**Rowley Lane, Lepton  
Proposed Internal Layout and Off-Site Highway Works  
Response Report to Road Safety Audit Stage 1**

April 2023 (Initial Issue)

1.2.1 This report provides a response to the items raised within a Stage 1 Road Safety Audits dated 3<sup>rd</sup> April 2023, prepared by Road Safety Initiatives, which considers the proposed internal layout and off-site highway works associated with the residential development of land off Hermitage Park, Lepton.

Appendix N Drawing 13015/GA/01 - Proposed Improvements to Penistone Road/Rowley Lane junction

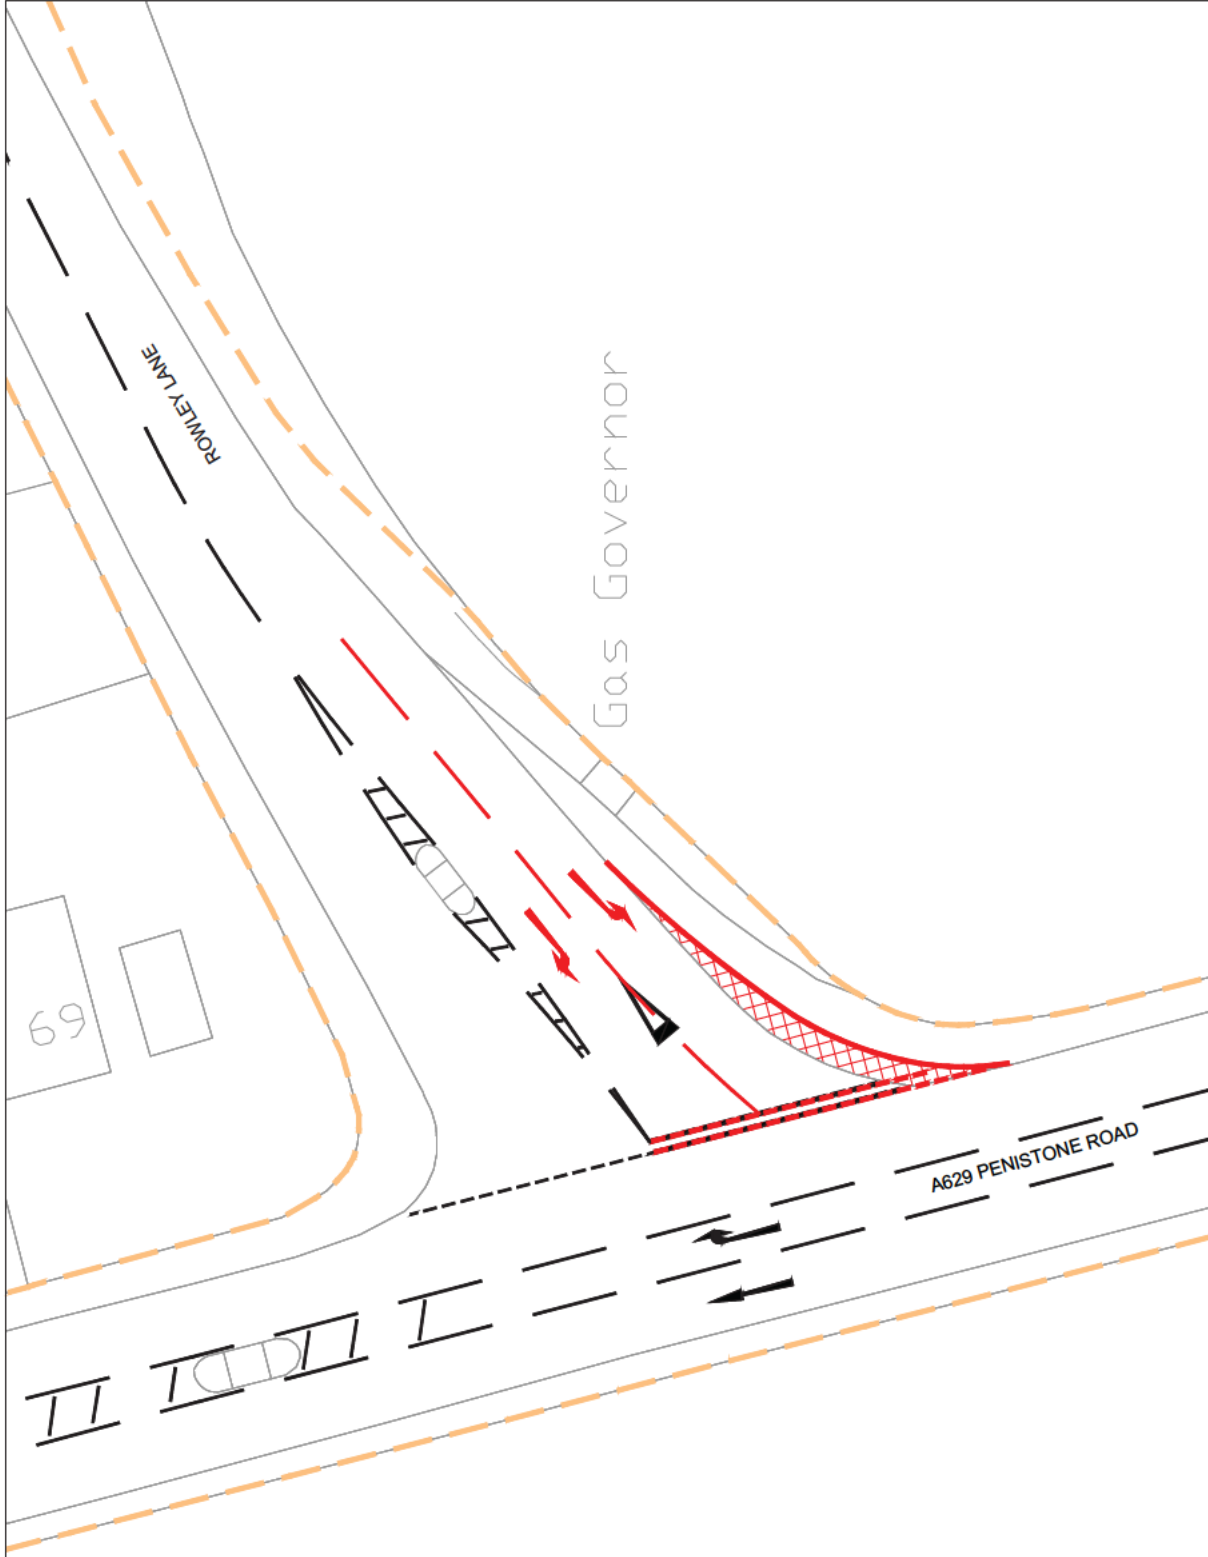
| <b>PROBLEM 3.1.1</b>  |  |
| <b>Location</b>   | A629 Penistone Road / Rowley Lane Junction.  |
| <b>Summary</b>  | Vehicles may encroach into the adjacent lane, leading to subsequent vehicle-to-vehicle collisions. |
| <p>In order to provide a two-lane approach to Penistone Road, the junction approach is to be realigned with changes to the verge alignment and the relocation of the pedestrian refuge island and hatching. It would appear that it may not be possible for vehicles (particularly large vehicles) to approach the junction side-by-side without encroachment into adjacent lane. Furthermore, the presence of roadside features i.e., trees, raised verge, road lighting and traffic signs may result in nearside 'verge shyness', which may exacerbate the situation.</p> <p>This could lead to vehicle-to-vehicle collisions, for-example side impact and head-on collisions.</p> <p>In a similar theme, the warning line bounding the hatched road markings may lead drivers into the traffic island kerbs and result in subsequent loss of control collisions.</p> |                 |
| <p>It is recommended that a swept path analysis demonstrates that vehicles can successfully and comfortably approach the junction without encroachment into adjacent lane.</p> <p>It is also recommended that the warning line should be offset from the traffic island kerb line.</p>  |  |

| RSA Problem  | RSA Recommendation   | Design Organisation Response  | Overseeing Organisation Response   | Agreed RSA Action   |
|--|--|---|--|---|
| <p><b>Problem 3.1.1: Junctions</b></p> <p><b>Location</b> – A629 Penistone Road / Rowley Lane Junction.</p> <p><b>Summary</b> – Vehicles may encroach into the adjacent lane, leading to subsequent vehicle-to-vehicle collisions.</p> <p><b>Detail</b> – In order to provide a two-lane approach to Penistone Road, the junction approach is to be realigned with changes to the verge alignment and the relocation of the pedestrian refuge island and hatching. It would appear that it may not be possible for vehicles (particularly large vehicles) to approach the junction side-by-side without encroachment into adjacent lane. Furthermore, the presence of roadside features i.e., trees, raised verge, road lighting and traffic signs may result in nearside ‘verge shyness’, which may exacerbate the situation.</p> <p>This could lead to vehicle-to-vehicle collisions, for example side impact and head-on collisions.</p> <p>In a similar theme, the warning line bounding the hatched road markings may lead drivers into the traffic island kerbs and result in subsequent loss of control collisions.</p> | <p><i>It is recommended that a swept path analysis demonstrates that vehicles can successfully and comfortably approach the junction without encroachment into adjacent lane.</i></p> <p><i>It is also recommended that the warning line should be offset from the traffic island kerb line.</i></p> | <p>RSA recommendation is Accepted.</p> <p>Analysis of the Penistone Road/Rowley Lane manually classified count (MCC) conducted on Thursday 19<sup>th</sup> September 2019 (contained within the TA) shows that no heavy goods vehicles were recorded making the right turn from Rowley Lane to Penistone Road during the hours of 07:00 – 10:00am and 14:00 – 19:00pm.</p> <p>Notwithstanding the above, drawing 13015/GA/01/REV/C contained within Appendix B demonstrates that the Kirklees refuse collection vehicle can approach the junction whilst vehicles are queuing within the adjacent approach lane and make both the left and right turns out.</p> <p>The proposed warning line has also been amended as per the recommendation and is now shown offset from the traffic island kerb line.</p> | <p>The amendments to proposed lining and swept path analysis are acceptable.</p> | <p>Proposed warning lines to be offset from traffic island kerb line.</p> |
